From: Charlotte Hardy
Sent: 02 October 2017 17:34
To: [REDACTED]
Cc: Michael Eastham; [REDACTED]
Subject: FRA v4 for BE/102/17/OUT

The main points were that as it is not purely an outline application being dealt with but a hybrid one, essentially the groundworks including the SUDS (detention basins/attenuation ponds), the village buffer, landscaping and a building would be approved. As such we will need some more detail to be provided for us to be satisfied in terms of the flood risk side, which as mentioned Michael will then need to reconsult with the necessary people for their views. Specifically, this starts with:

SALTBOX SITE – BOGNOR REGIS

FLOOD RISK ASSESSMENT

REFER TO SHEETS 4 & 5 FOR CONTINUATION

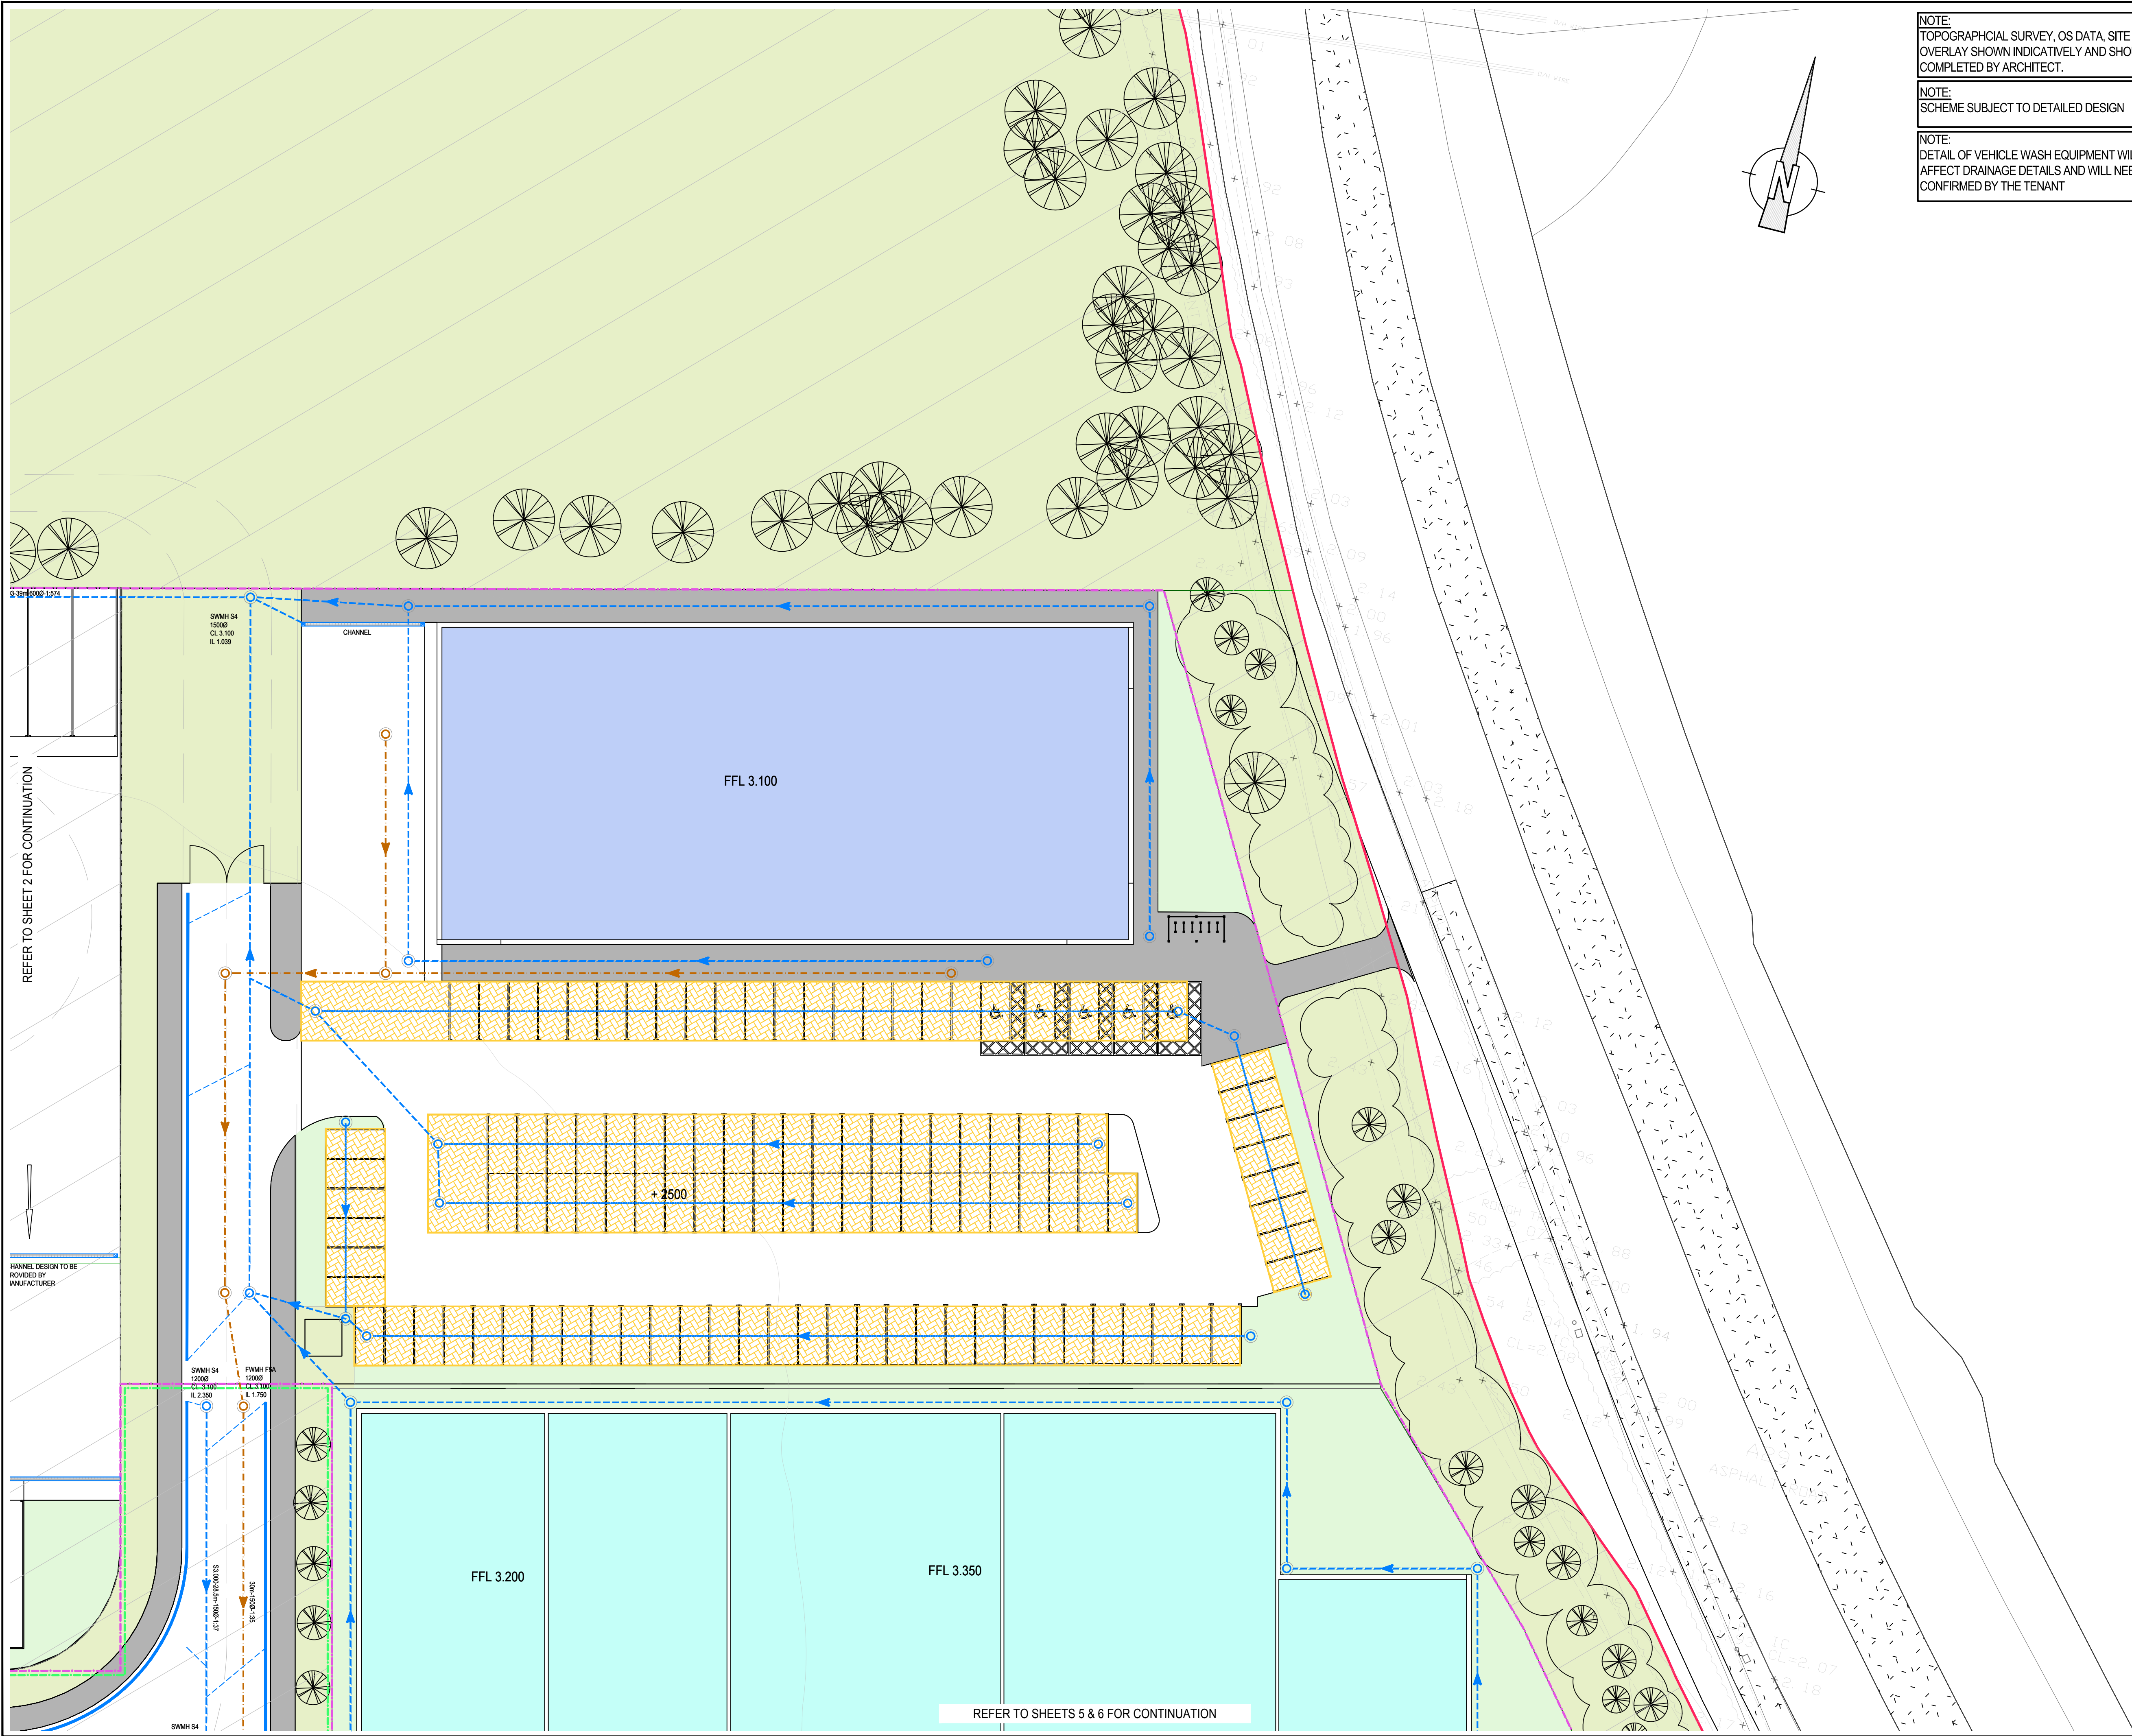
1. Information relating to the groundwater levels across the site
2. The treatment plant, along with the expected connections
3. The survey work of the watercourse and details, for certainty to be gained over the achievability of the gravity connection
4. The achievability of delivering the detention basin as shown in the buffer area considering SSEs plans for the pylons.
